Application No: WA/18/26/PL
Site Address: Land off Arundel Road Fontwell
Description of works: Erection of 64 residential dwellings with access off Arundel Road, together with associated parking, open space, play space, landscaping, drainage and infrastructure. This application is a Departure from the Development Plan, affects a Public Right of Way, may affect the setting of listed buildings and is in CIL Zone 3 and is CIL Liable as new dwellings.

Thank you for your internet representation made on 21st April 2026 which has been recorded as an objection with the comments as follows:

I have the following comments on Drainage

Southern Water Sewer Records

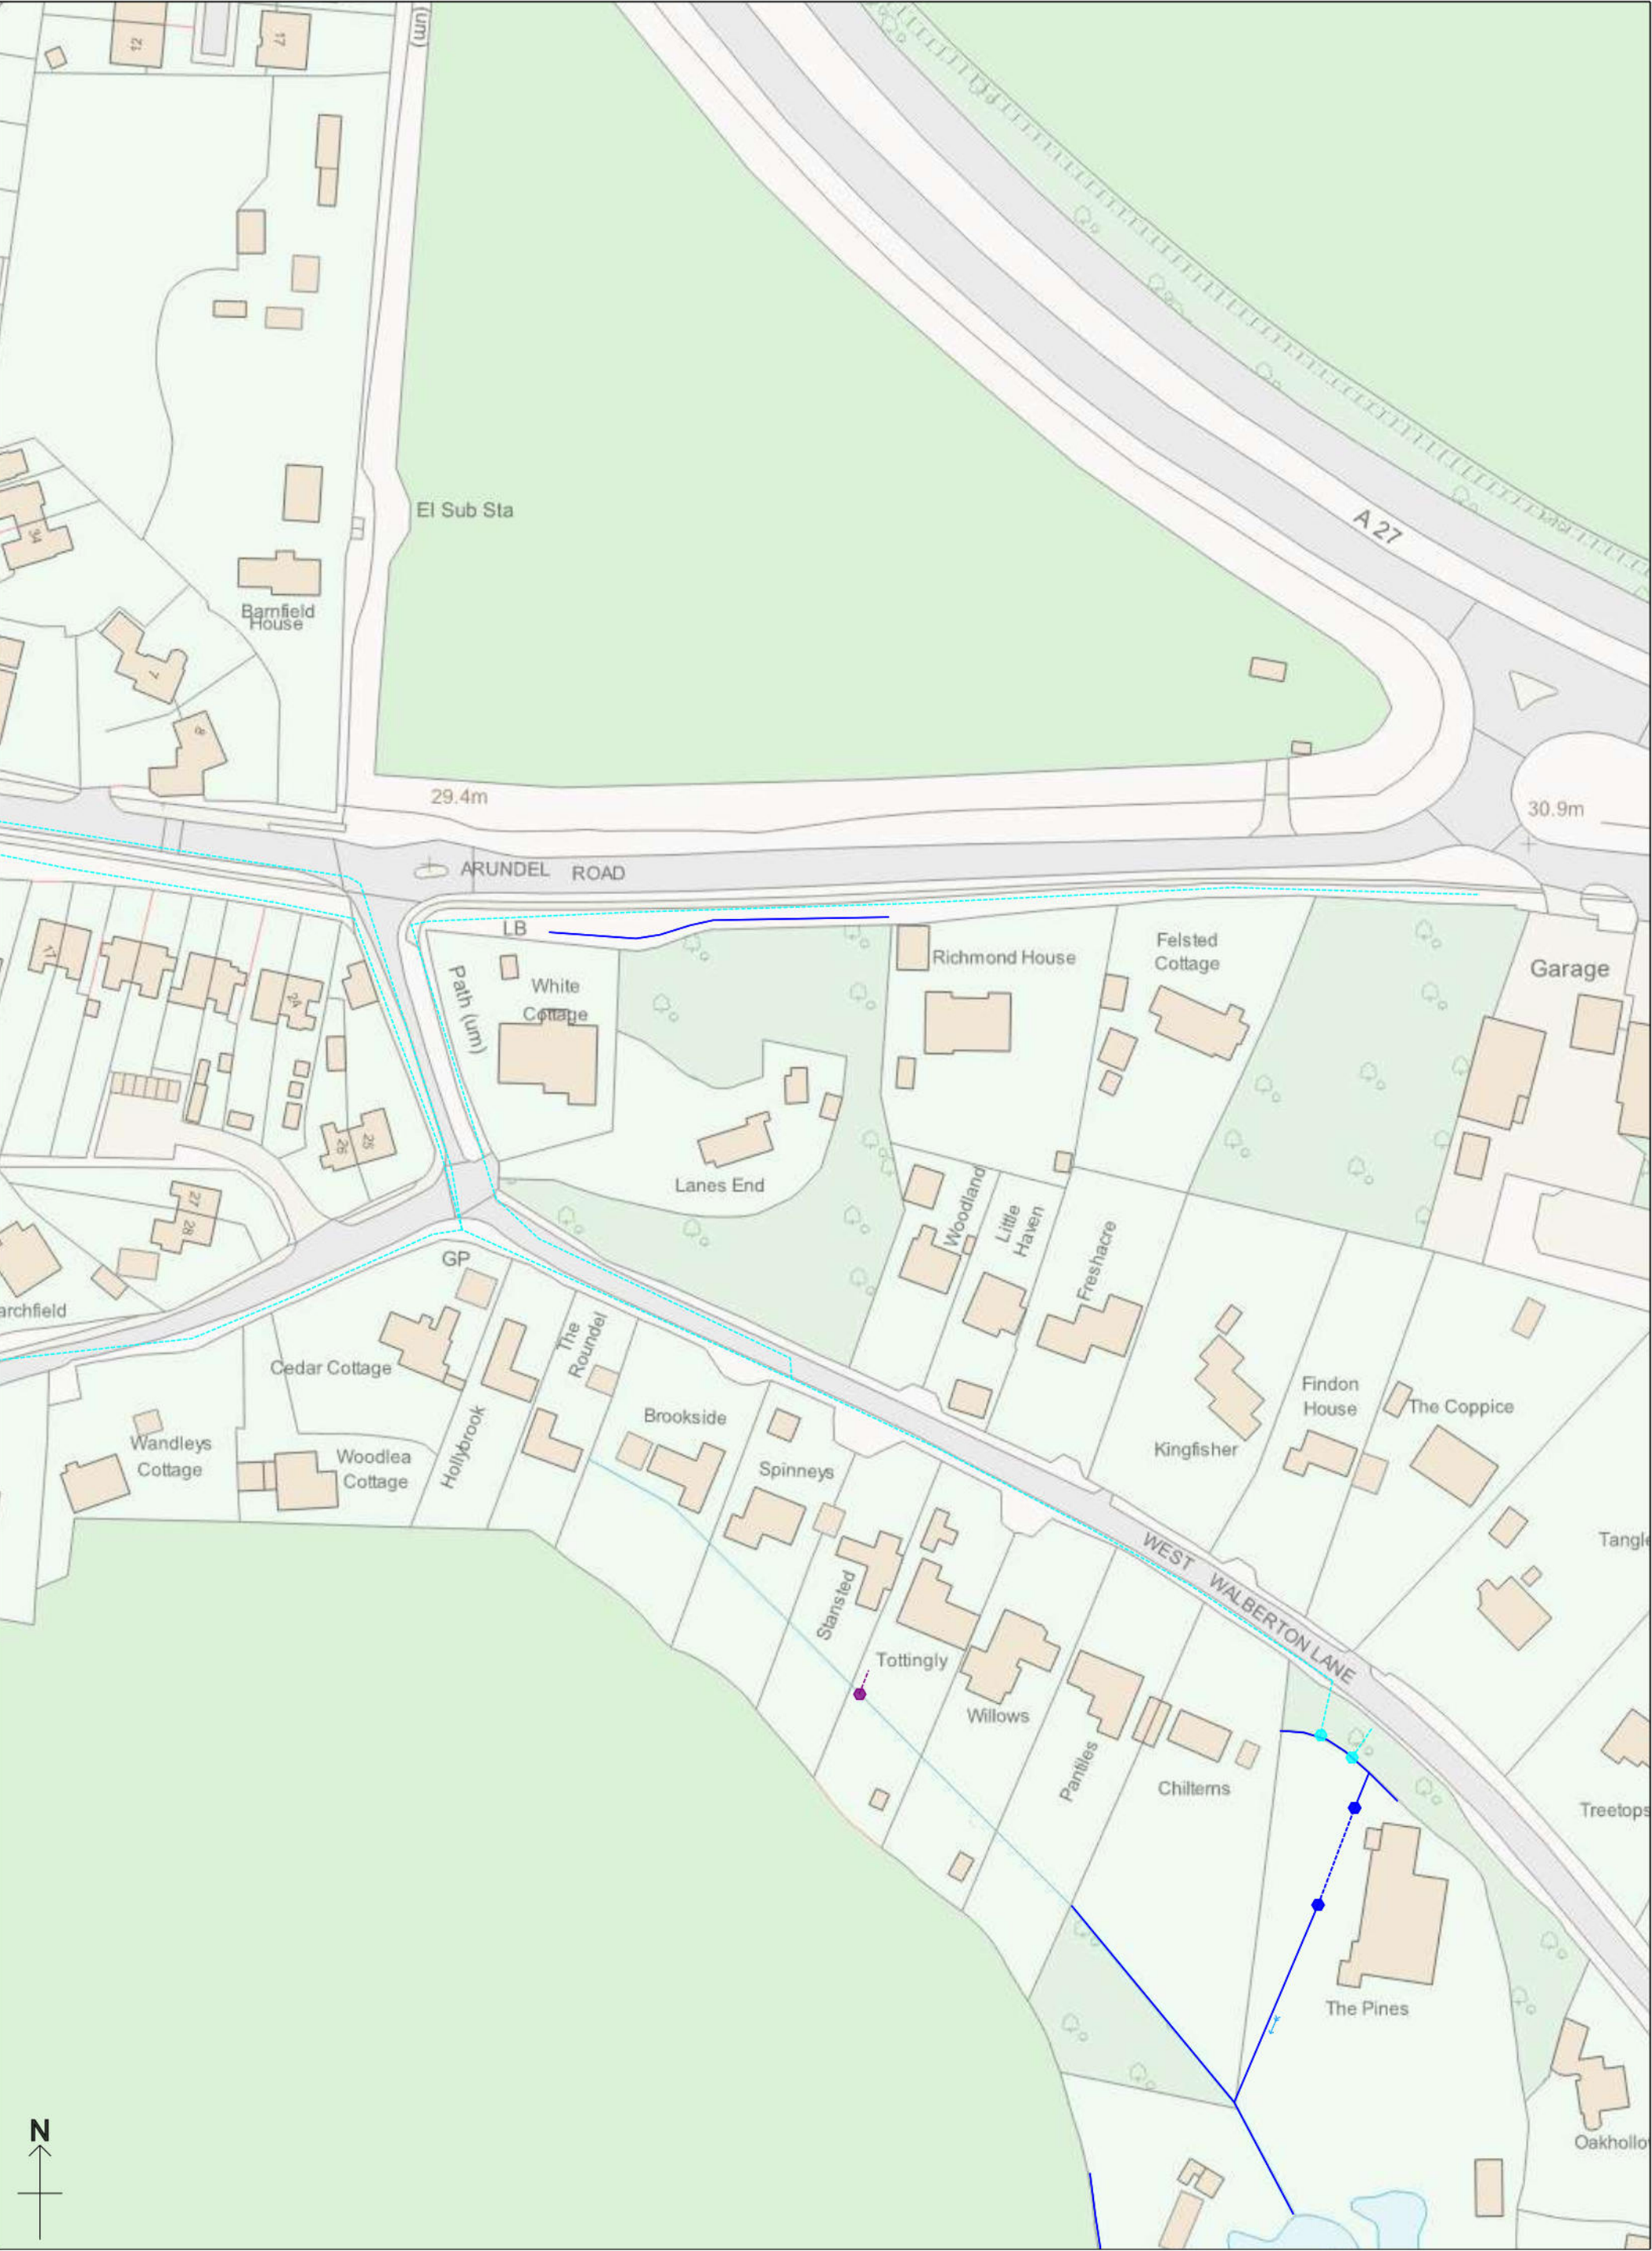
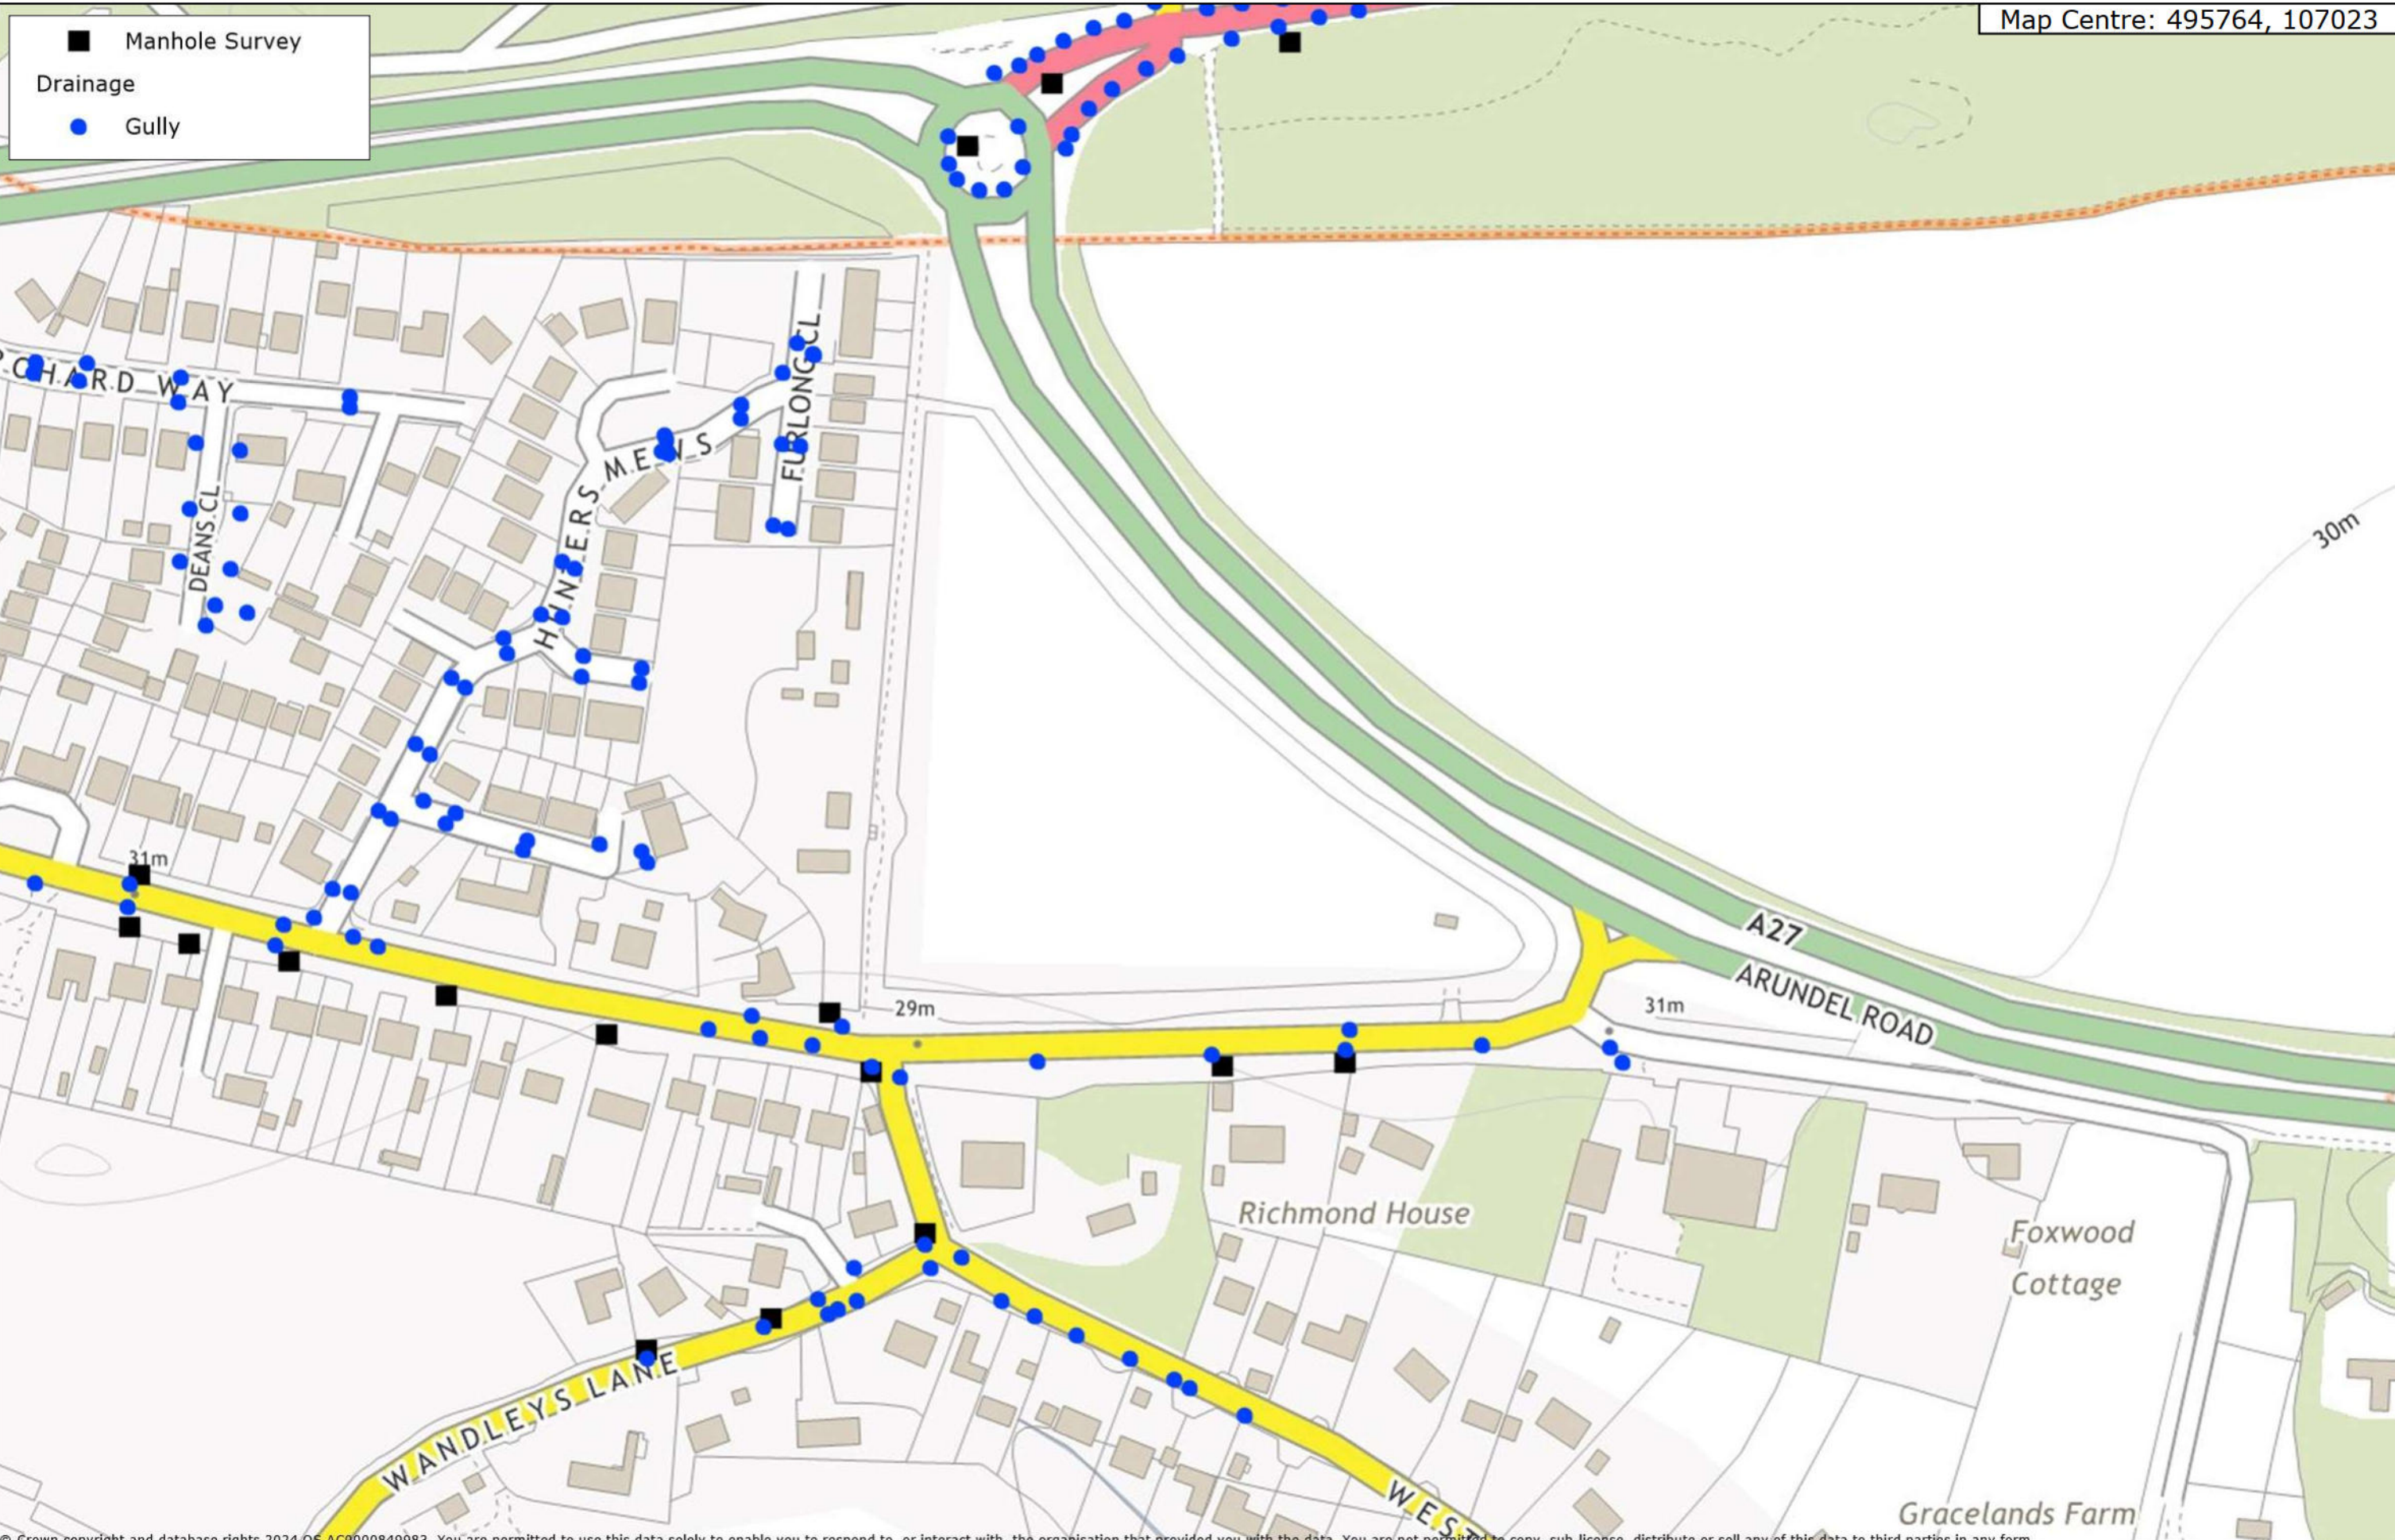
I also wish to bring to your attention that the plot shown for my property is incorrect on Southern Water network map and that the pipework from manhole 7803 to 7804 is entirely under my drive way. That section was highlighted in the Lidsey SWMP Table 7.3 which states "Public Sewer flooding is due to hydraulic overload in West Walberton Lane caused by clear water inflow into the public foul sewer system through infiltration of ground water and surface water inflows/inundation. It was top of the list for future action but I have not been made aware of any proposal to take action.
